East Anglia One North (EA1N) and East Anglia Two (EA2) Offshore Wind Farms

Planning Inspectorate Reference: EA1N – EN010077 & EA2 – EN010078

Deadline 5 - 3 February 2021

**East Suffolk Council's Response to Examining Authority's Action Points Following
Issue Specific Hearings 3, 4, 5 and 6**

|  | 4 | 09/09/2019 | AB | Fourth Issue. | | | 1:25,000 |  | East Anglia TWO Offshore Wind Farm | | | Drg No | EA2-DEV-DRG-IBR-000693 | |

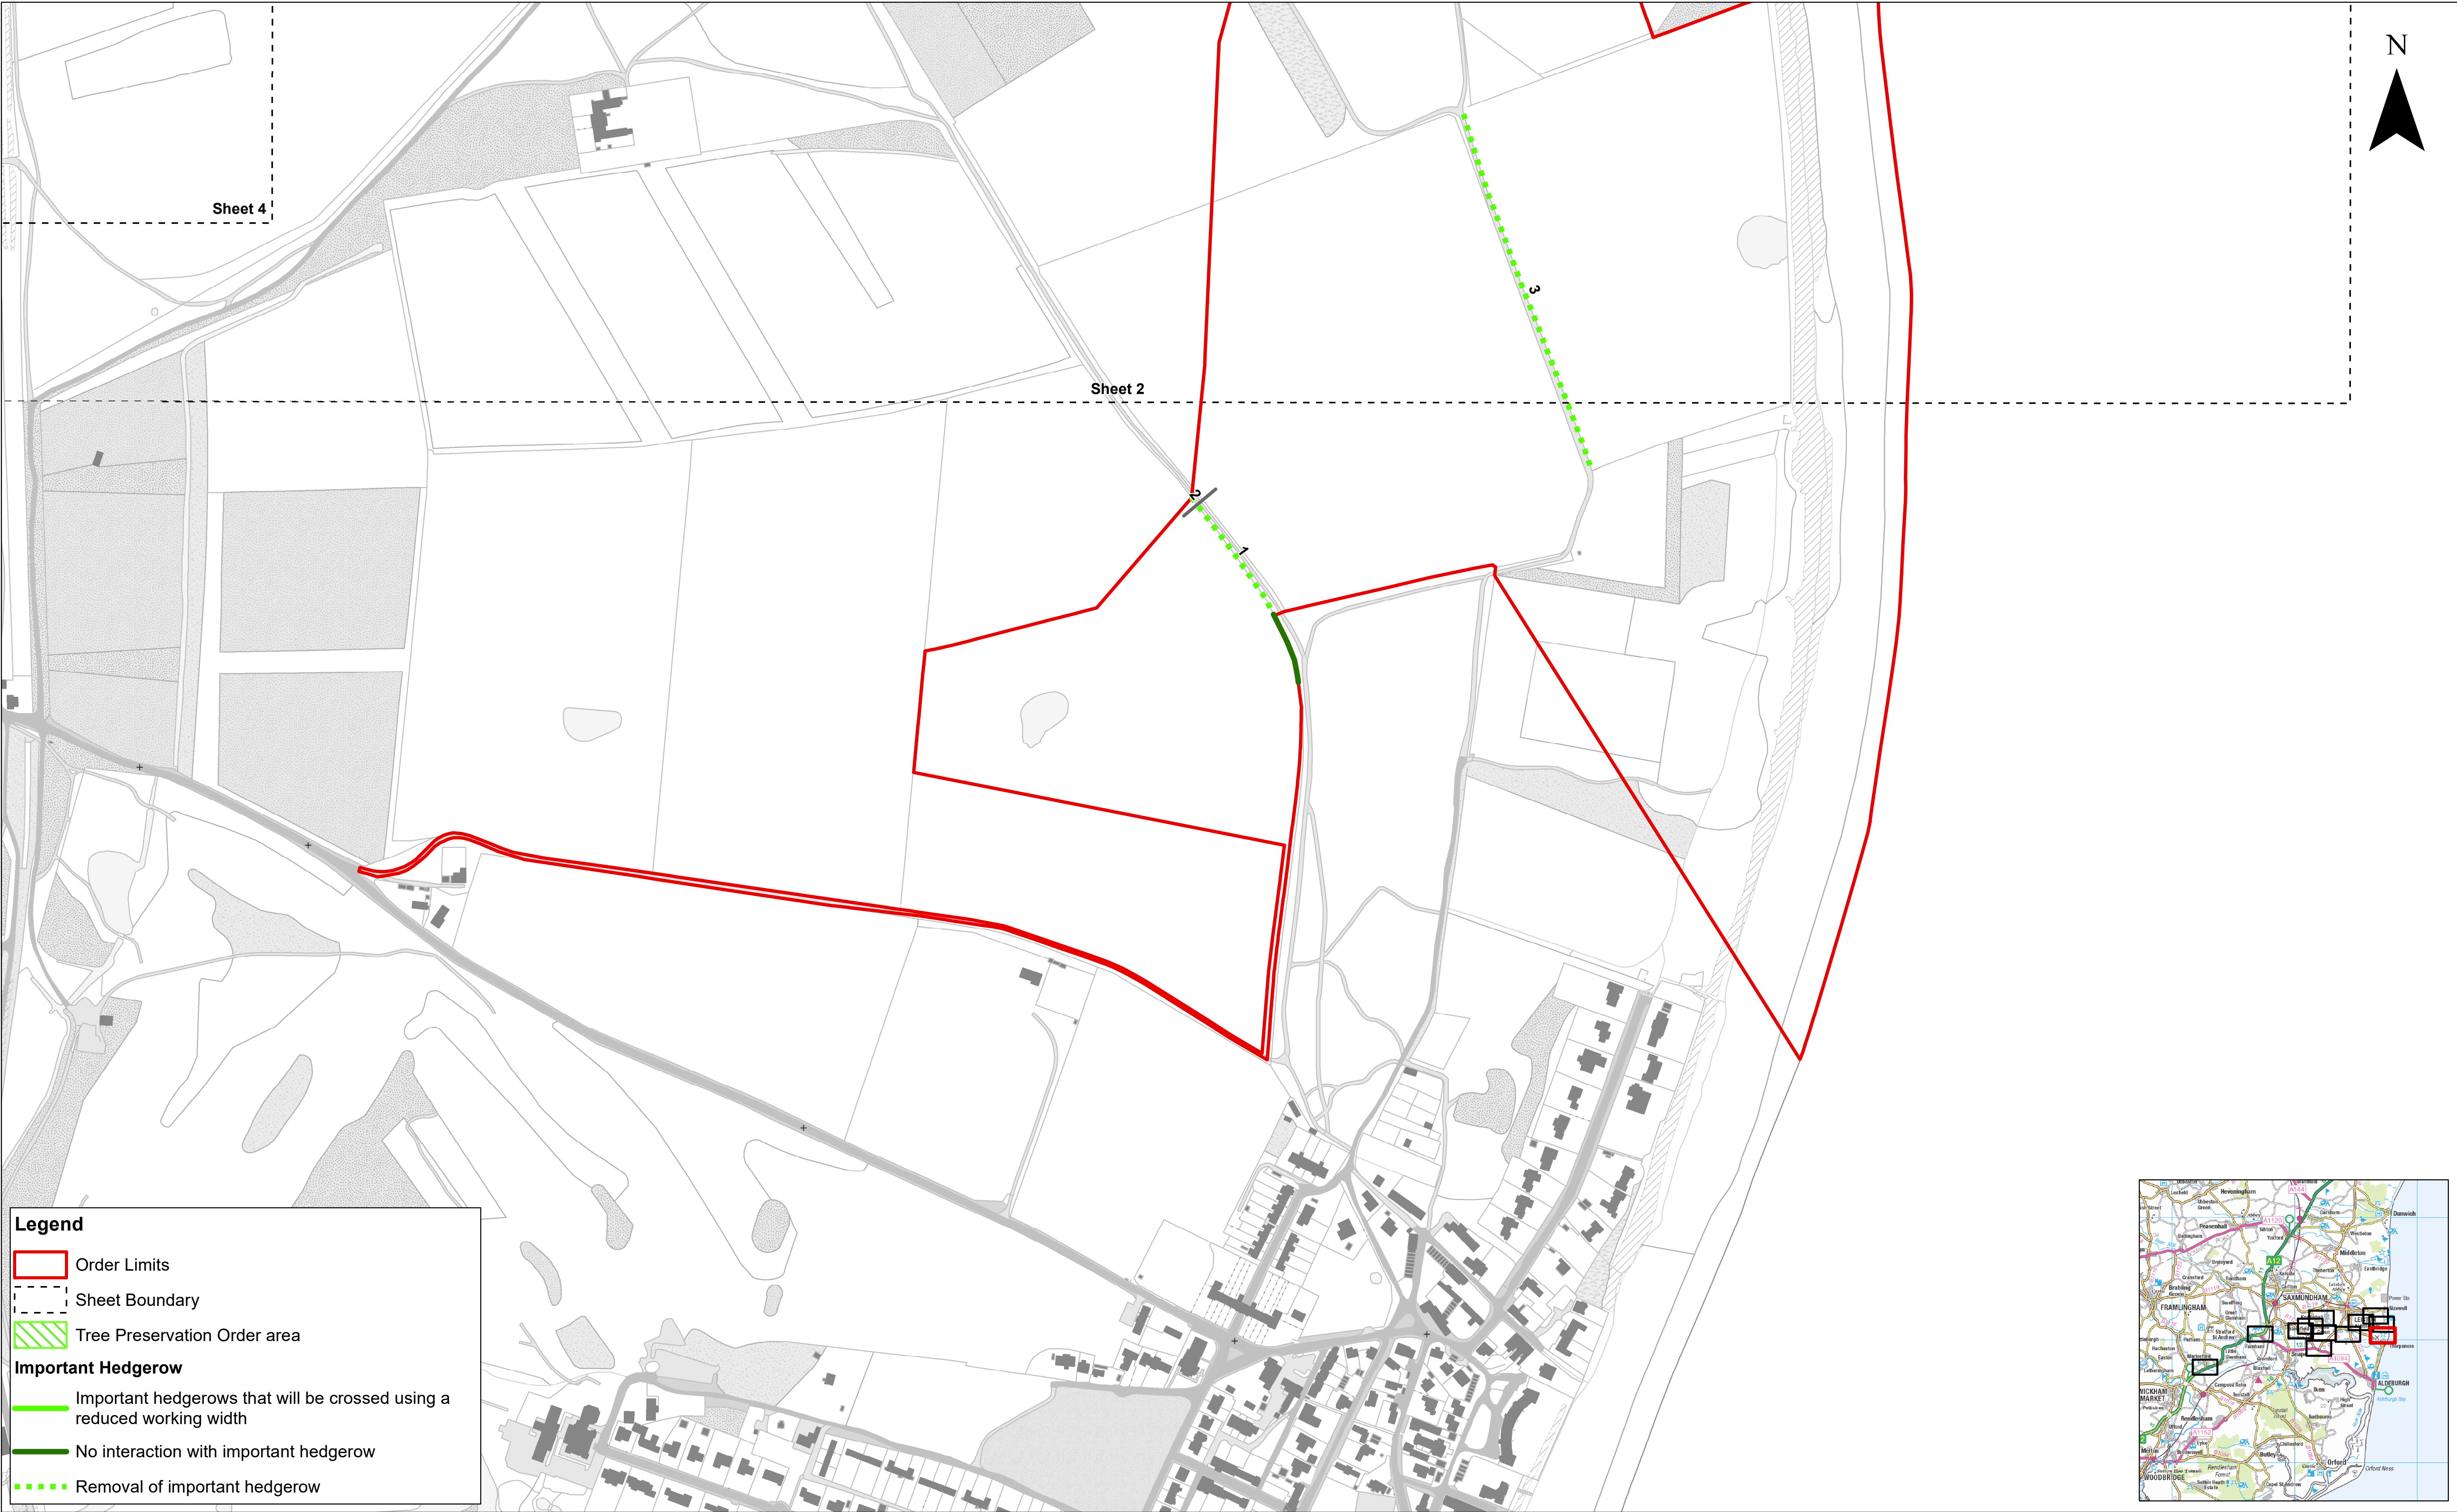
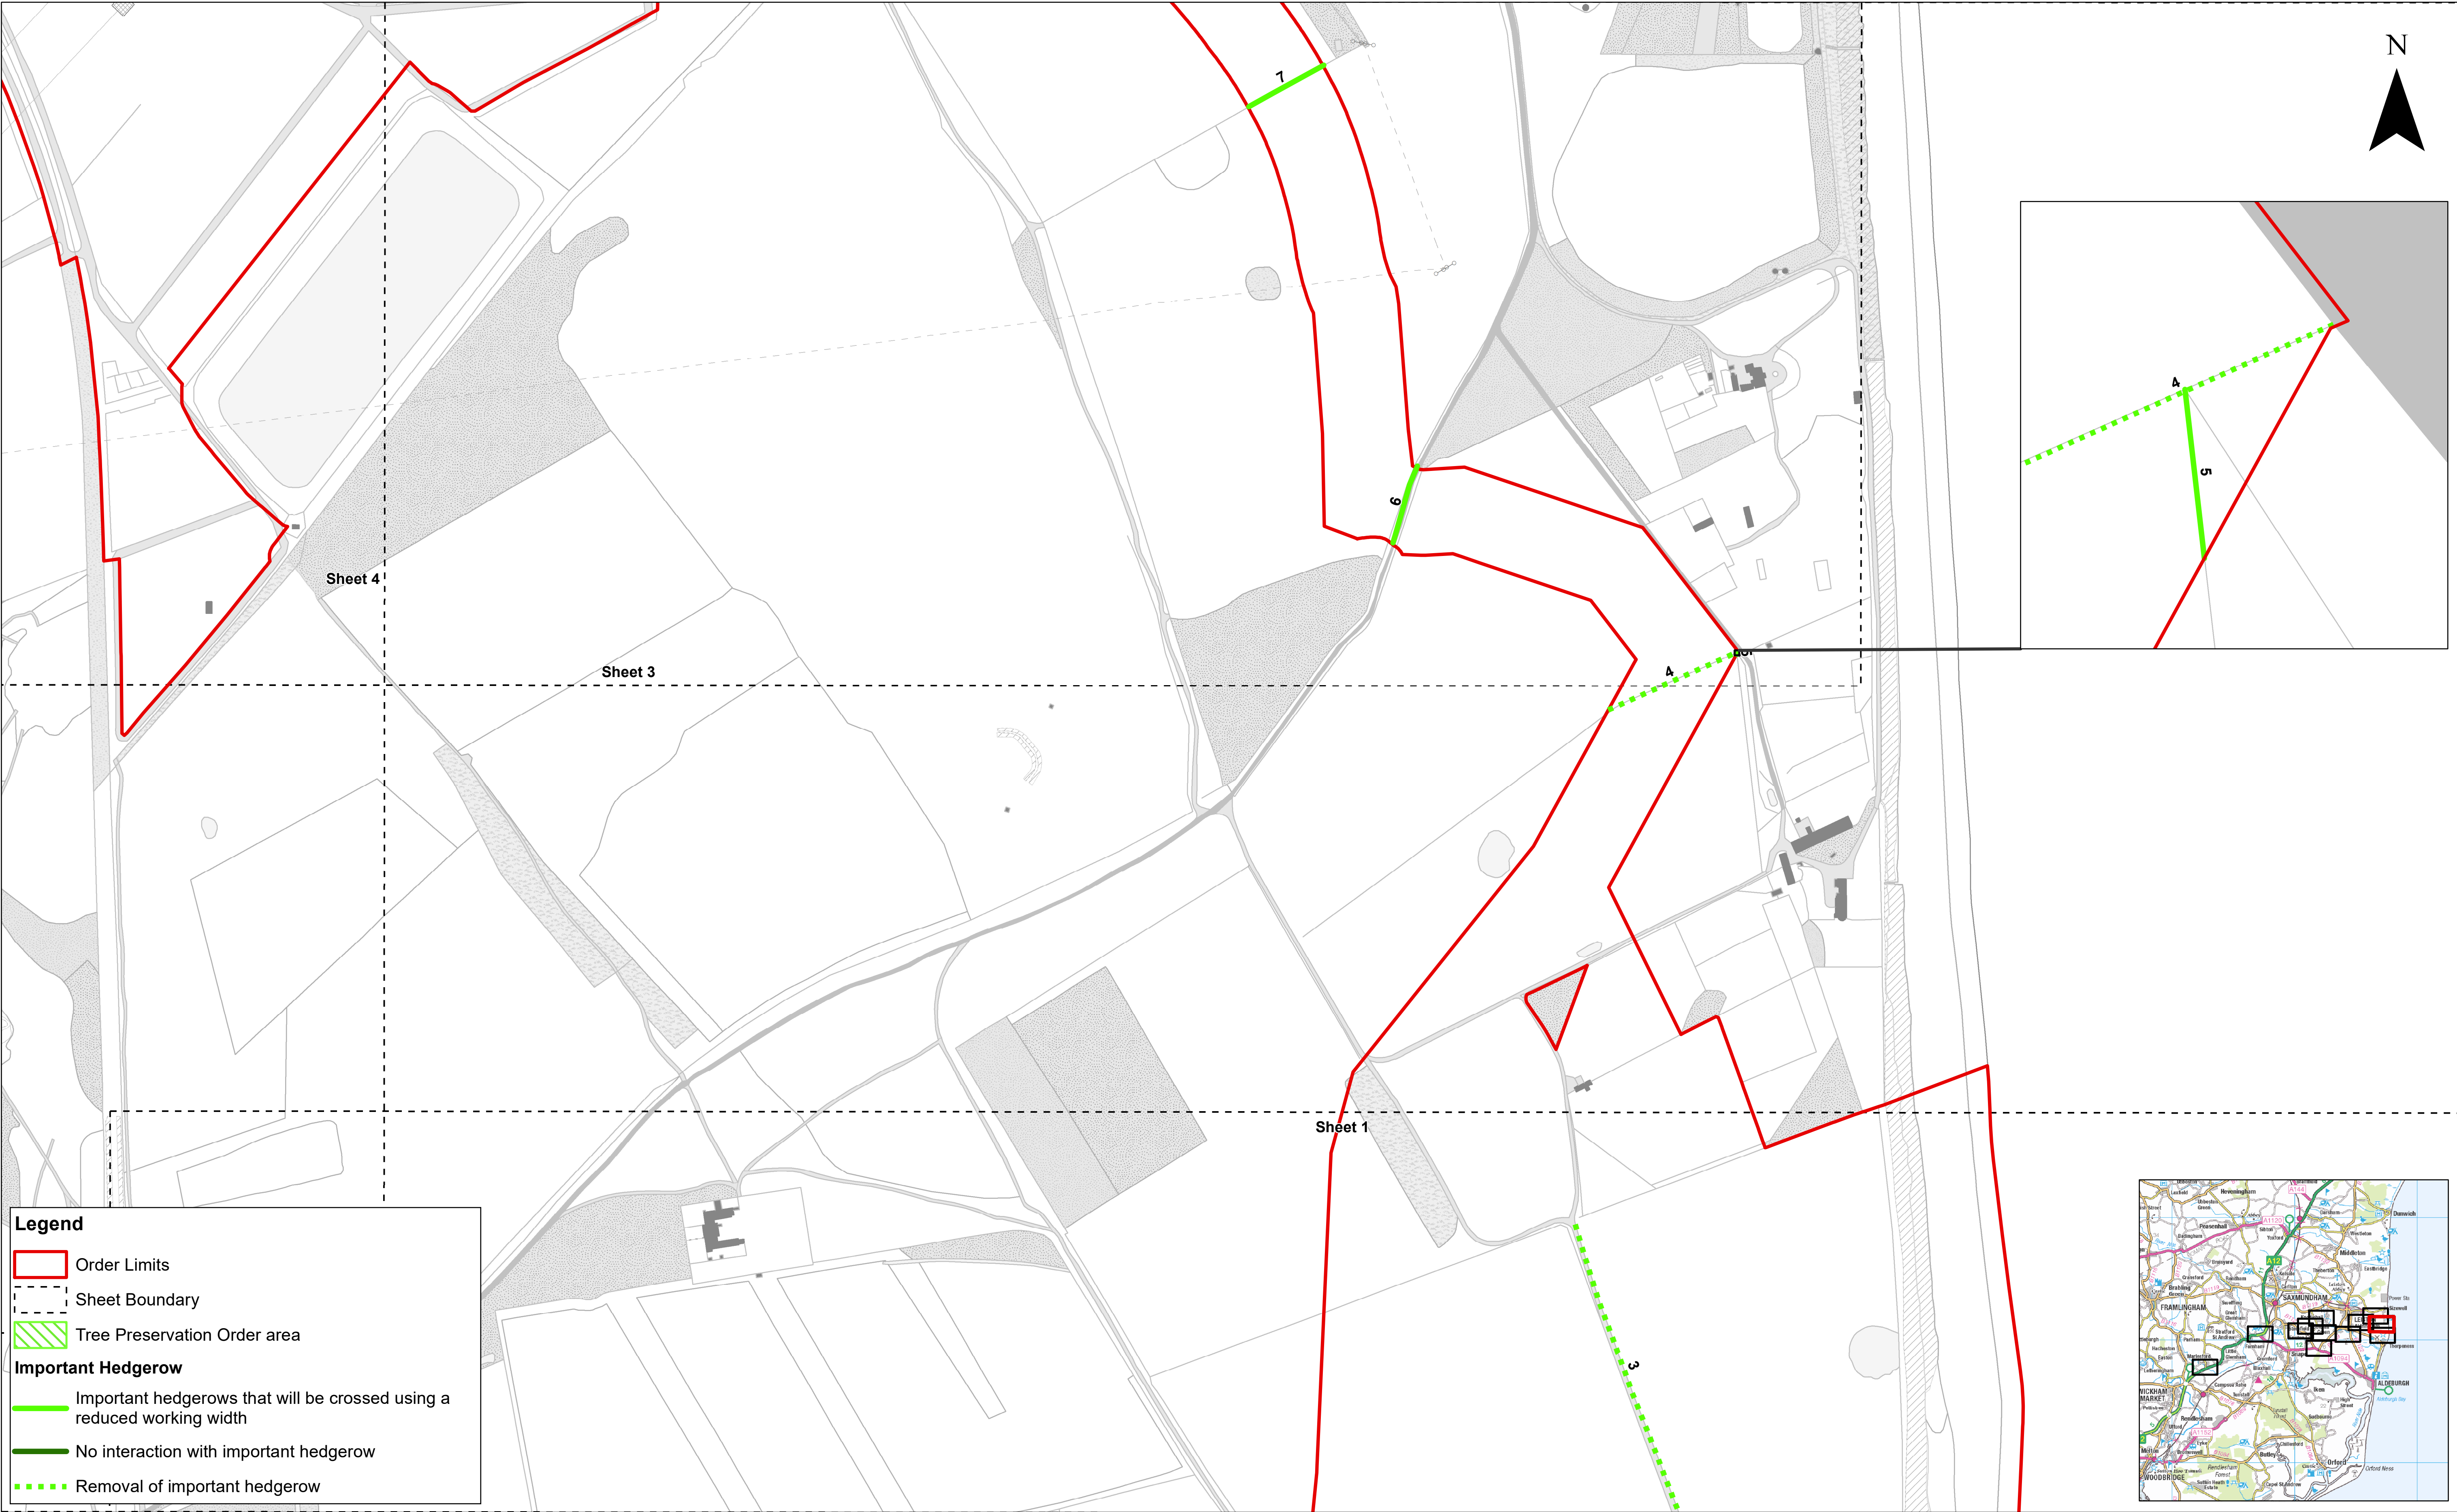
<p>ESC has been in discussion with the Applicants in relation to the removal of land parcel no.3 from the draft DCOs.</p> <p>Schedule 8 – Modification of compensation and compulsory purchase enactments for creation of new rights and imposition of new restrictions – ESC has no comments.</p> <p>Schedule 9 - Land of which temporary possession may be taken.</p> <p>ESC has been in discussion with the Applicants in relation to the removal of land parcel no.3 from the draft DCOs.</p> <p>Schedule 10 – Protective provisions – ESC has no comments.</p> <p>Schedule 11 - Hedgerows</p> <p>ESC seeks clarity regarding the hedgerows identified within Schedule 11 of the draft DCOs.</p> <p>Hedgerows marked 1 and 2 are identified within Schedule 11 (REP3-011) as being removed but on the Important Hedgerows and Tree Preservation Order Plan (REP3-010) they are identified as being crossed with a reduced width. Annex 1 of the OLEMS document (REP3-030) identifies hedgerows 1 and 2 as being subject to full or partial removal. Clarification on this is required.</p>

<p>Clarification is also required in relation to hedgerow marked 28 which is identified on the Important Hedgerows and Tree Preservation Order Plan (REP3-010) as being removed but is not identified within Schedule 11 as being removed and identified in Annex 1 of the OLEMS (REP3-030) as not subject to interaction.</p> <p>The interaction identified within Annex 1 of the OLEMS (REP3-030) in relation to a number of hedgerows does not appear to correspond to the interaction identified within Schedule 11 of the draft DCOs (REP3-011) and the interaction identified on the Important Hedgerows and Tree Preservation Order Plan (REP3-010). Further clarification as to the reasons for this is required. Does Annex 1 identify a greater number of important hedgerows to be crossed with a reduced width as some of these will be crossed with a width less than 32m but greater than the draft DCOs definition of reduced width which is 16.1m?</p> <p>Schedule 12 – Trees subject to tree preservation orders – ESC has no comments.</p> <p>Schedule 13 – Deems licence under the 2009 Act – generation assets – ESC has no comments.</p> <p>Schedule 14 – Deemed licence under the 2009 Act – offshore transmissions assets – ESC has no comments.</p>
